Your ref:
Our ref: 23/00198/F
Please ask for: Mrs Lesley Raby
Direct dial: 01553 616818
E-mail: borough.planning@west-norfolk.gov.uk

Details: **Construction of traditional wooden cart shed & potting shed. at Glebe Farm
Wells Road North Creake Fakenham Norfolk**

I have received a planning application as detailed above but cannot process it until I receive some more information:

SOUTH ELEVATION.

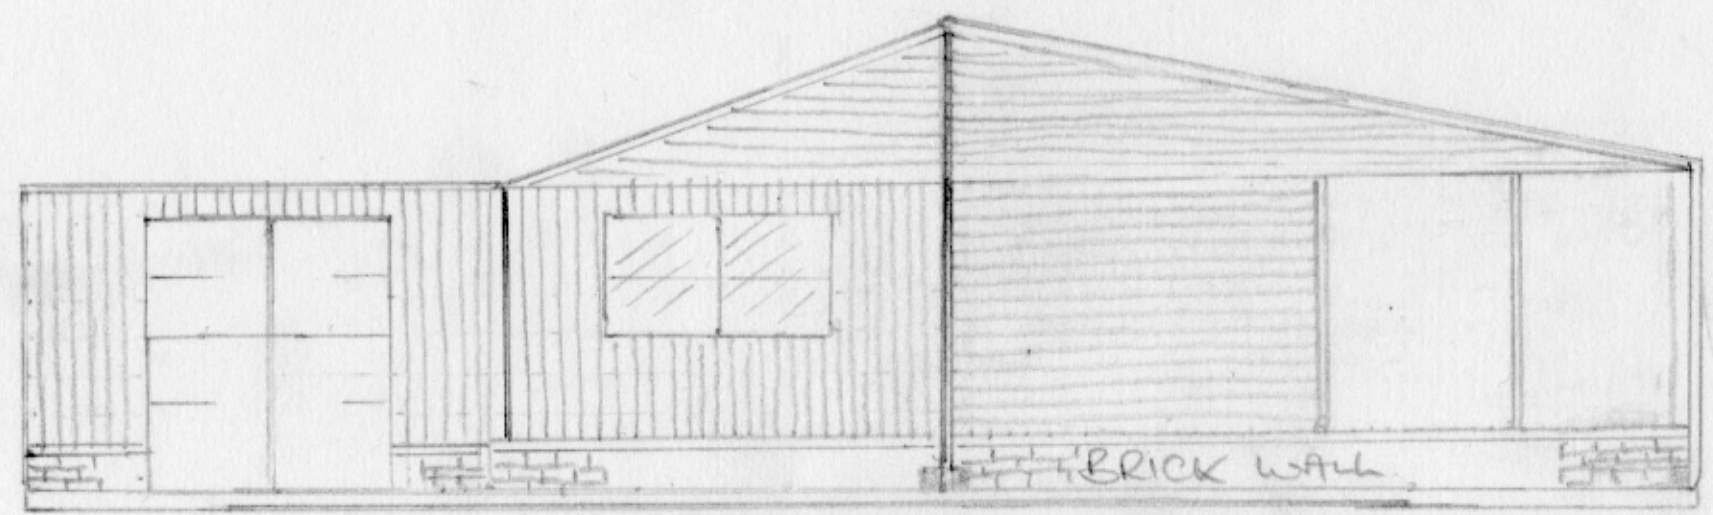
1. Provide a roof plan
2. The South elevation shows a lean-to at the back of the machinery store 1m wide, this is not shown of the North elevation.
3. The red line on the location plan should be around your residential boundary and not just the new proposed building. the same as the plan submitted with the 22/00122/PREAPP.
